PLANNING CONSULTATION RESPONSE

Application No	2026/0650
Proposal	Erection of building for vehicle maintenance (Use Class Sui Generis) and associated infrastructure including fuelling facilities; truck and plant wash facilities with surfacing works and formation of parking, following the demolition of existing buildings and structures.
Address	Wordsworth Business Park Whaley Road, Barugh, Barnsley, S75 1FJ
Date of Consultation Reply	18/09/2026
Consultee	Katie Lawrence, Planning Ecologist

**Proposed Site Plan
External Finishes**

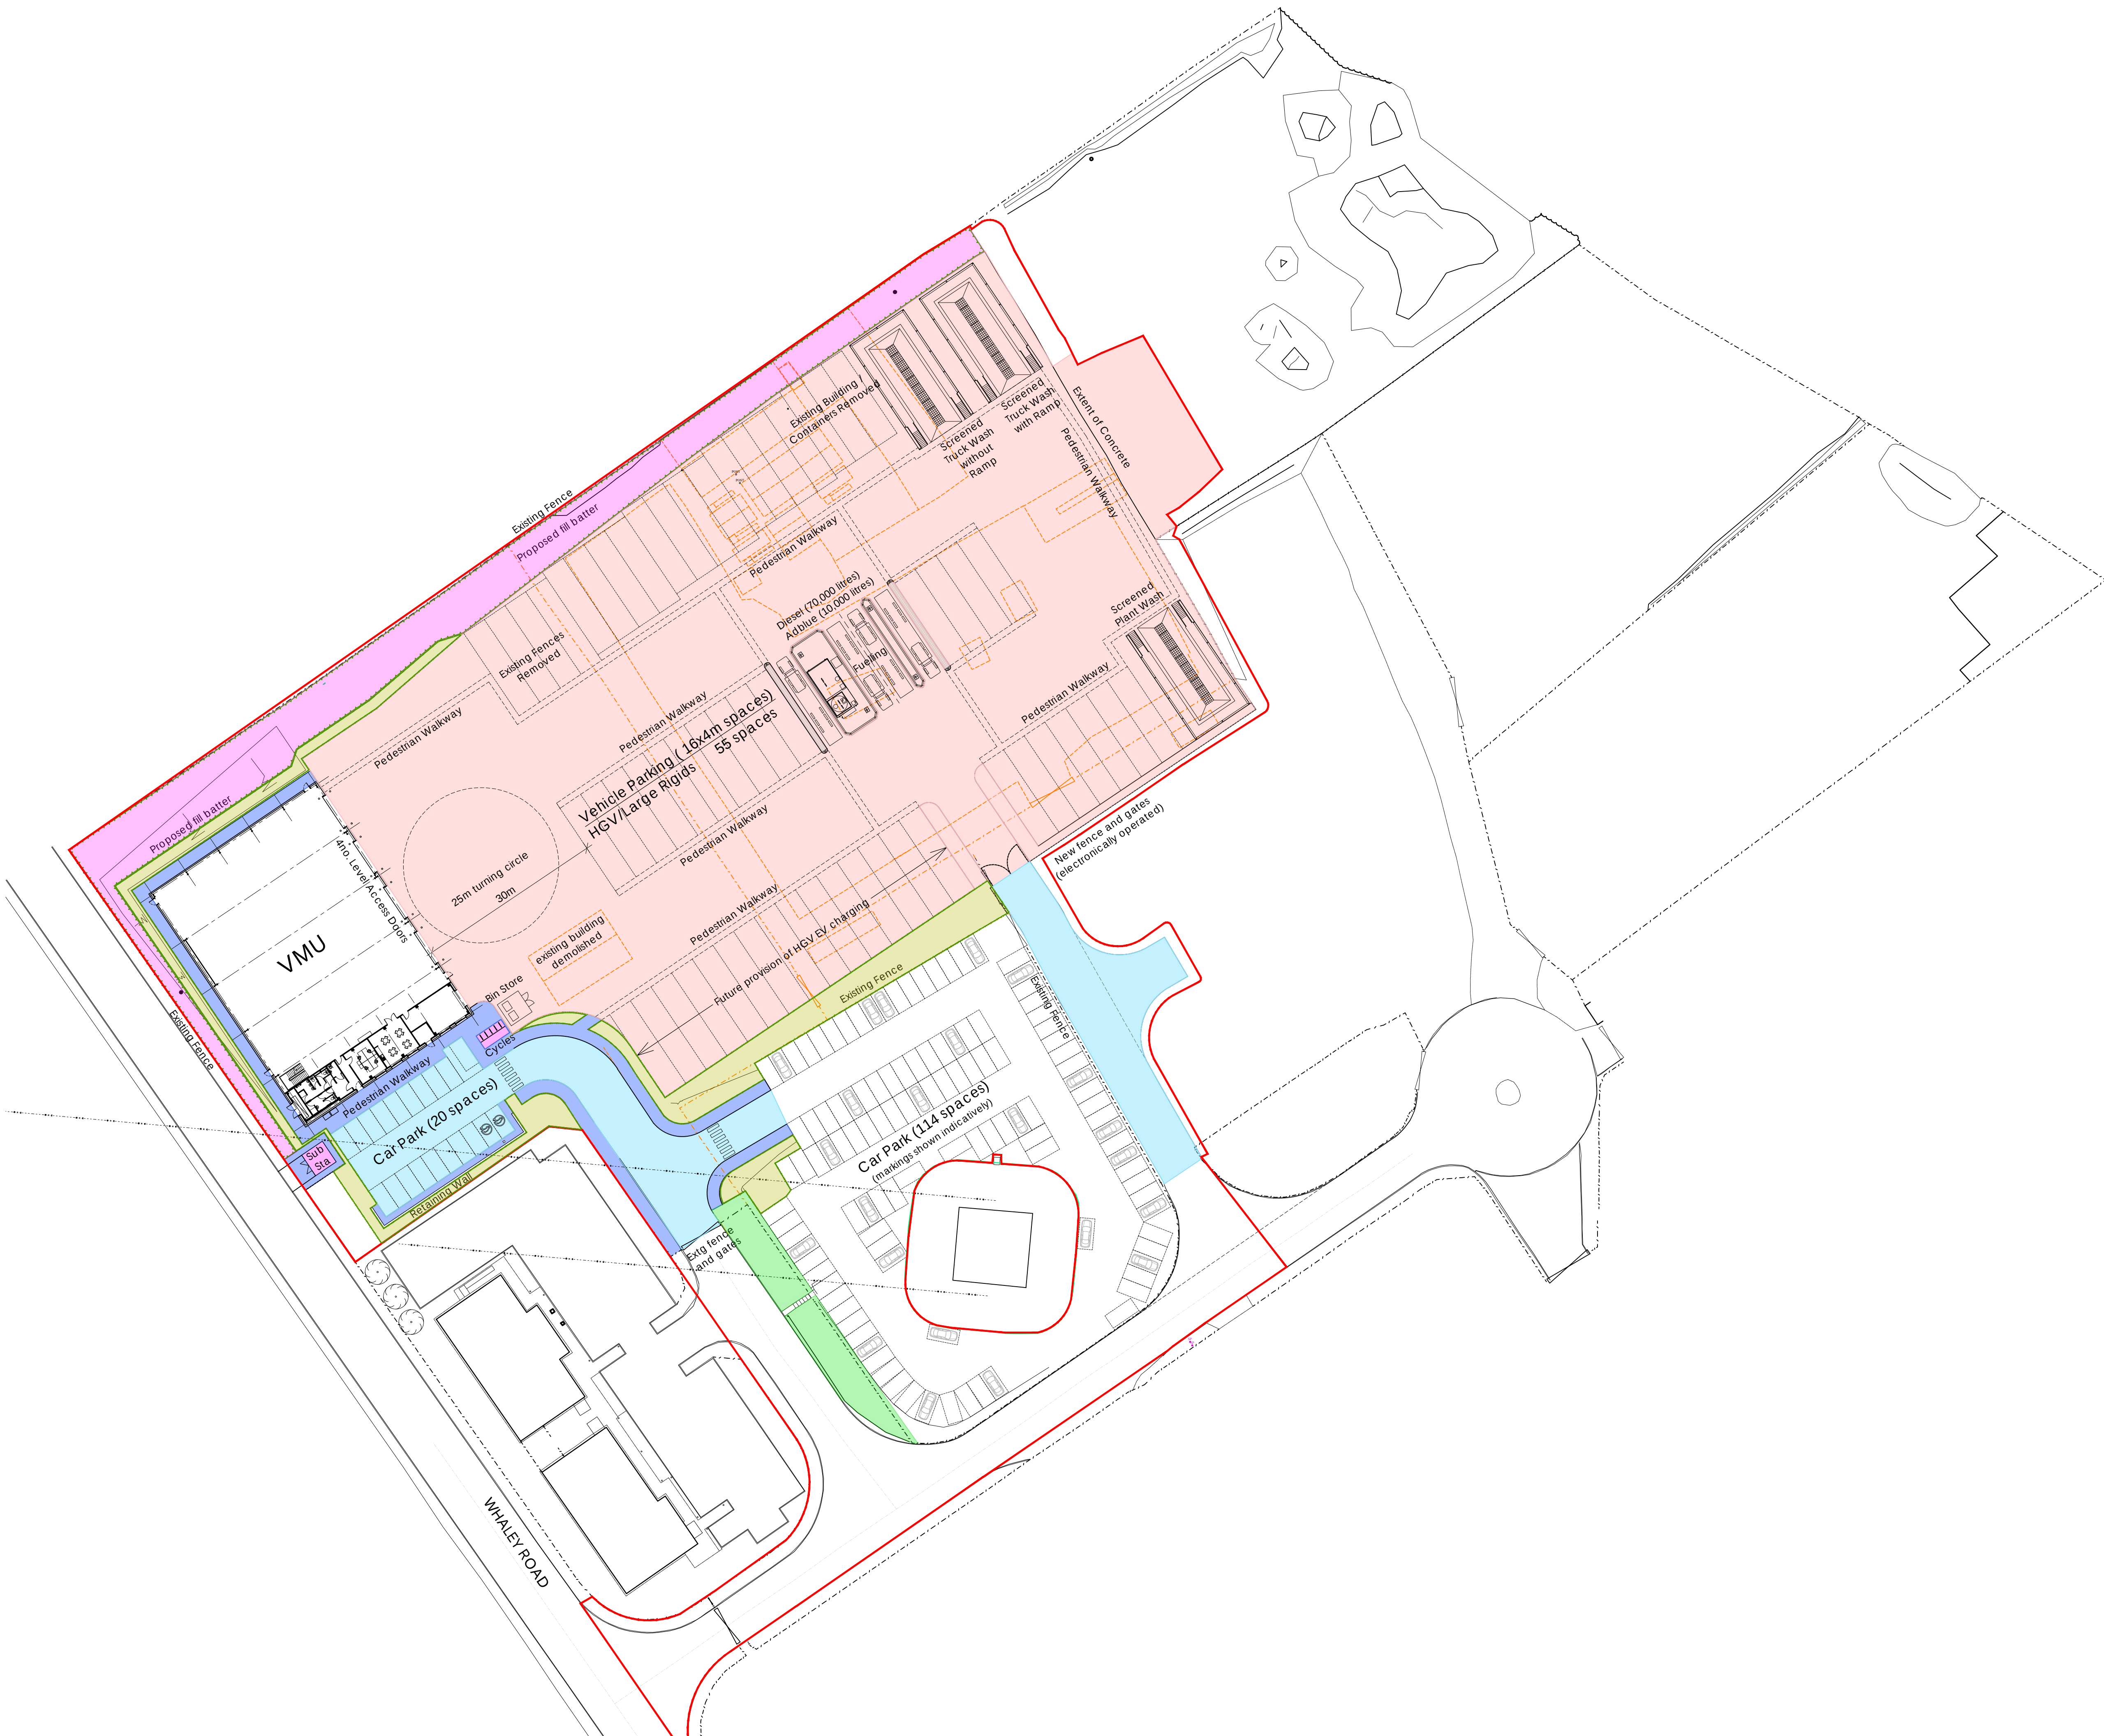
- Shrub planting, a medium distinctiveness habitat of poor condition is proposed to the eastern and northern boundaries of the site to mitigate the loss of existing scrub and also assist in achieving over a 10% net gain in biodiversity. Other habitats proposed for retention and creation are of low distinctiveness. Although only poor condition native shrub habitat is targeted, a Habitat Management and Monitoring Plan (HMMP) condition is still required as per the thresholds set within the Biodiversity Appendix of our local validation requirements. Native shrub is a medium distinctiveness habitat and the extent of planting proposed will aim to enhance habitat connectivity within the surrounding area as set out within the PEA. On this basis, it is considered that the management and monitoring of the habitat should be secured appropriately.
